File no: MC-15-909
SSD-8375

5 December 2019

**Notification of exhibition of a State Significant Development Application for the
Pick n Payless Metal Recovery and Recycling Facility located at 57-69 Tattersall
Road, Kings Park**

Plan No.
CC160136-1-503
File Ref.
CC160136
REV.
A

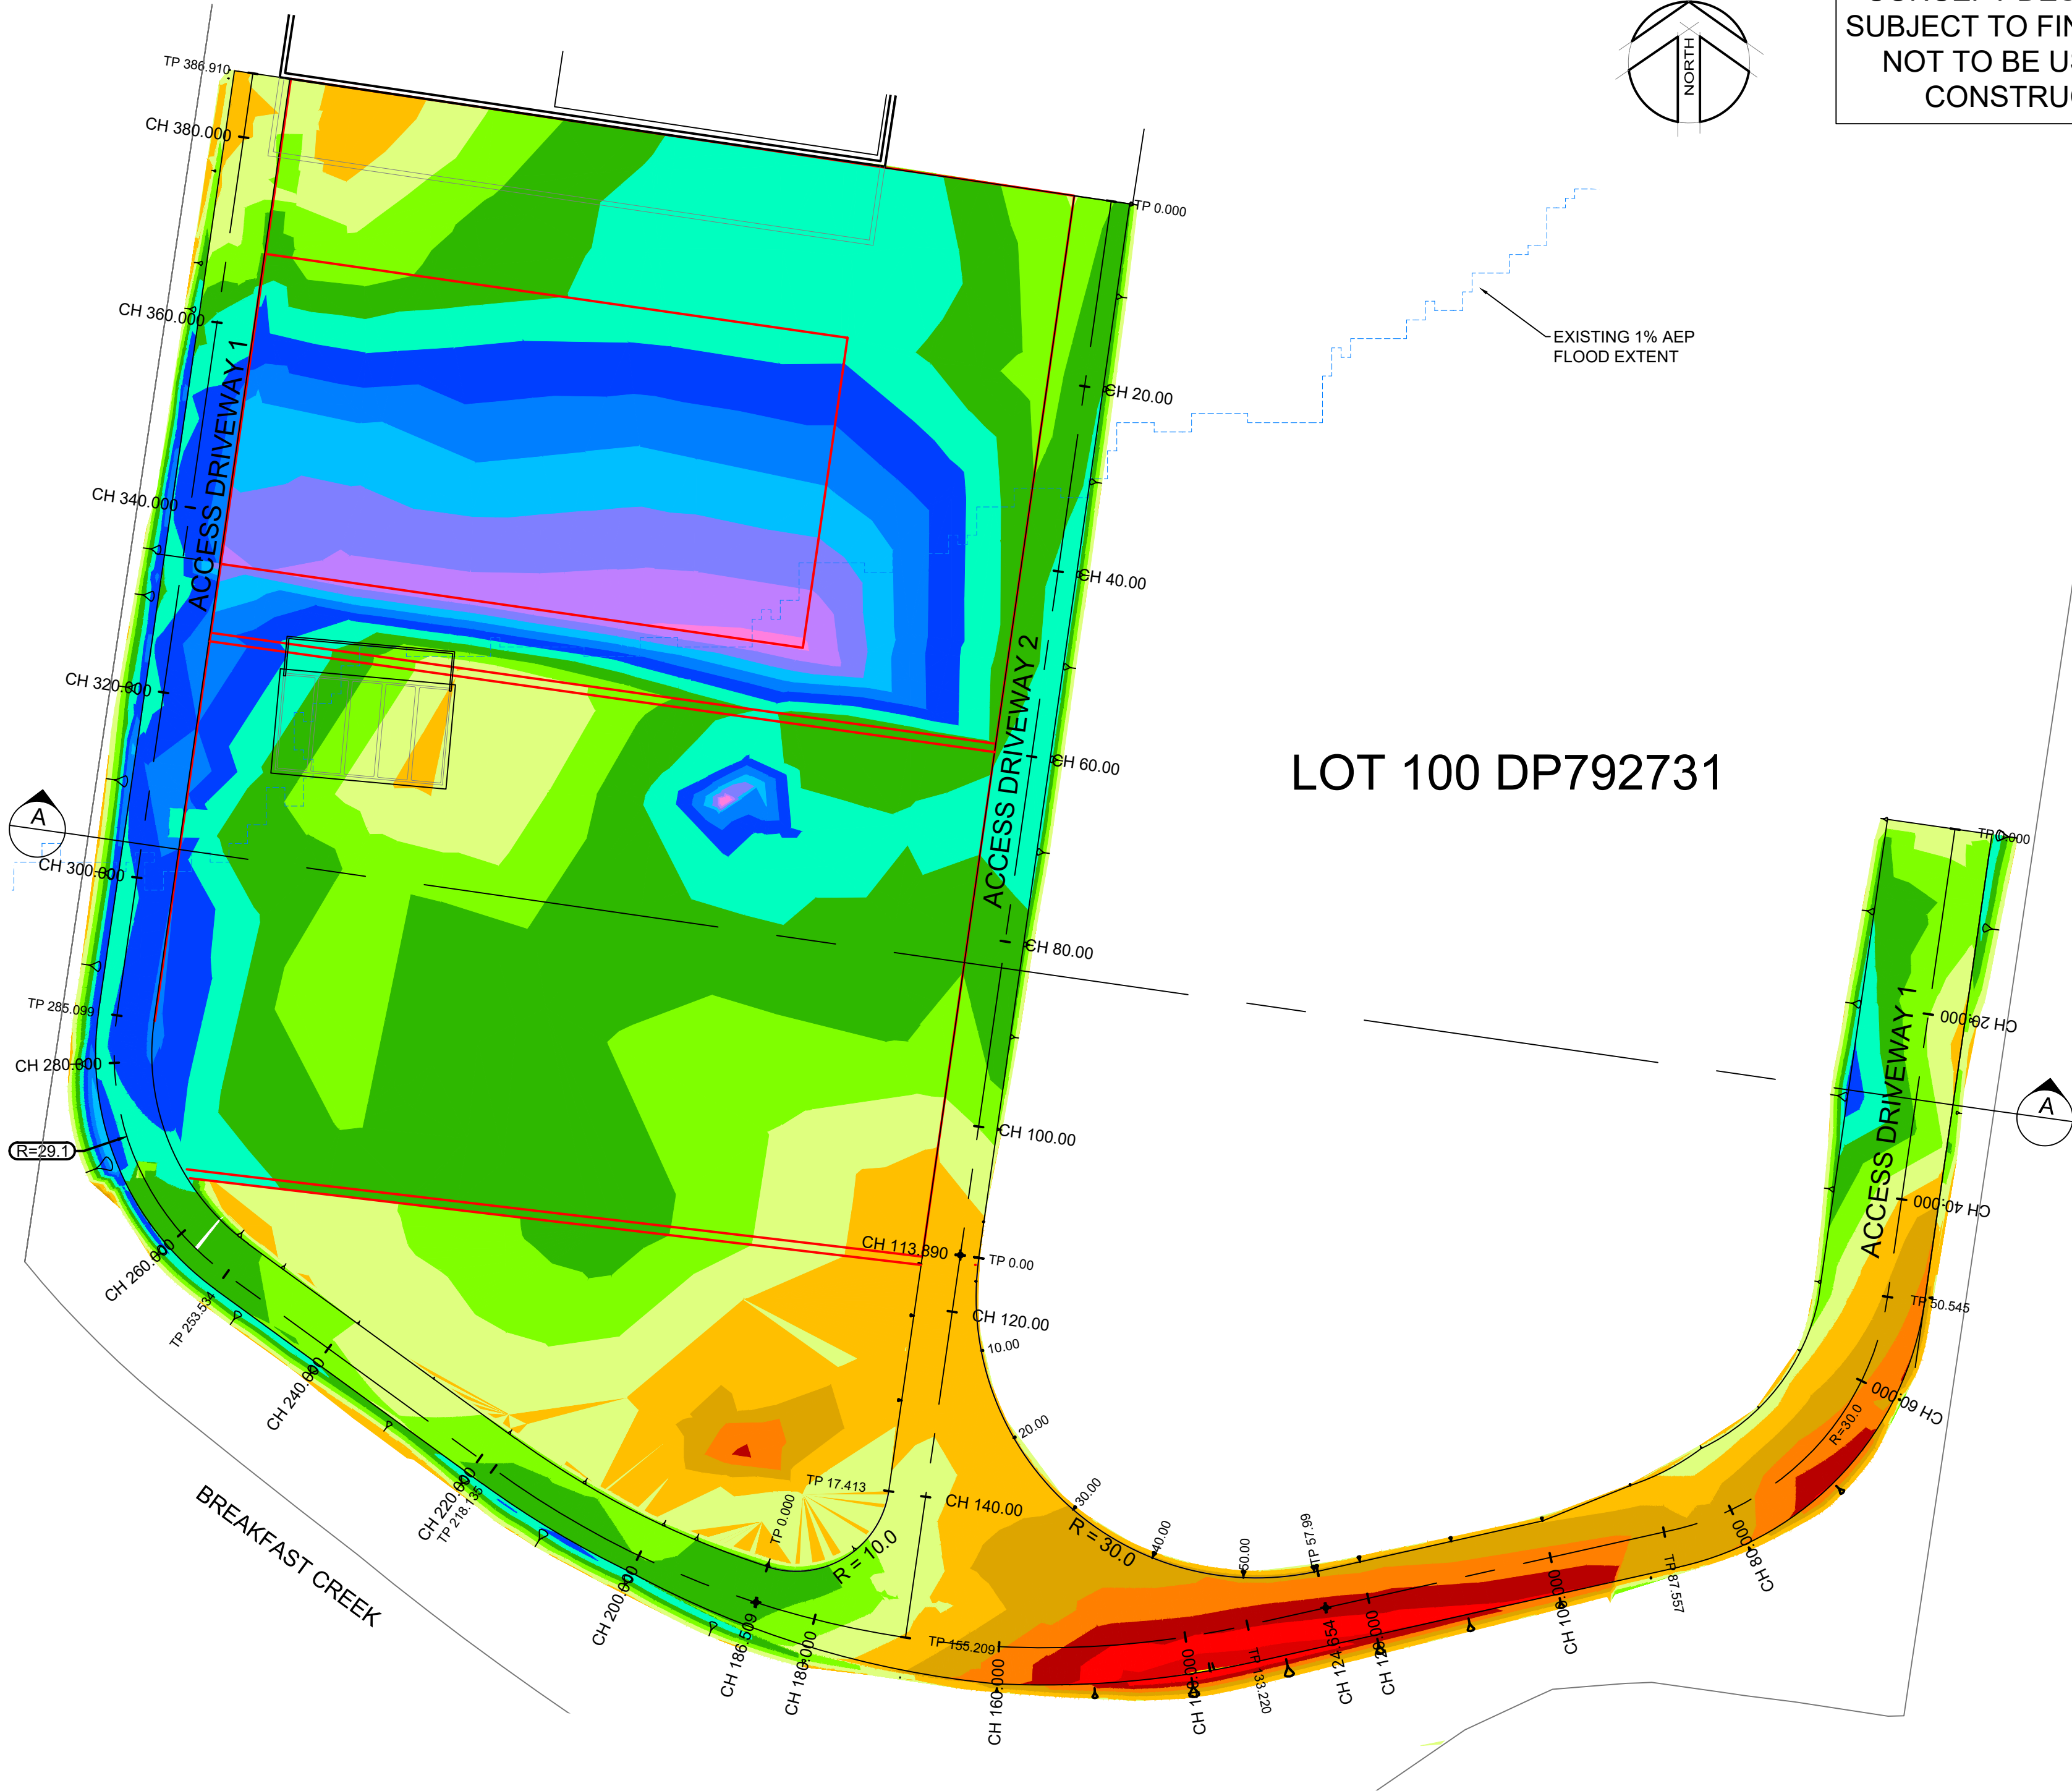
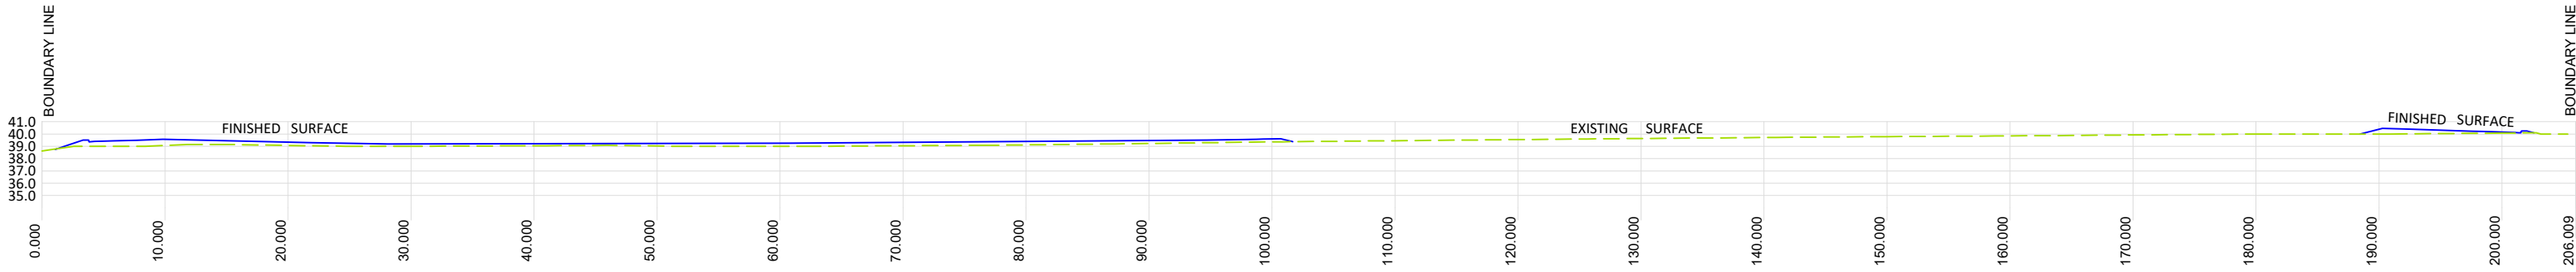
- xvi. On drawing 503 (A) delete the Stormfilters and Stormfilter chamber from the tank as full on lot treatment is not required.
- xvii. On drawing 503 (A) at Section A-A the base of the tank at 35.99 is well below the orifice centreline level of 36.40 and won't drain. Raise base to ensure it can drain.
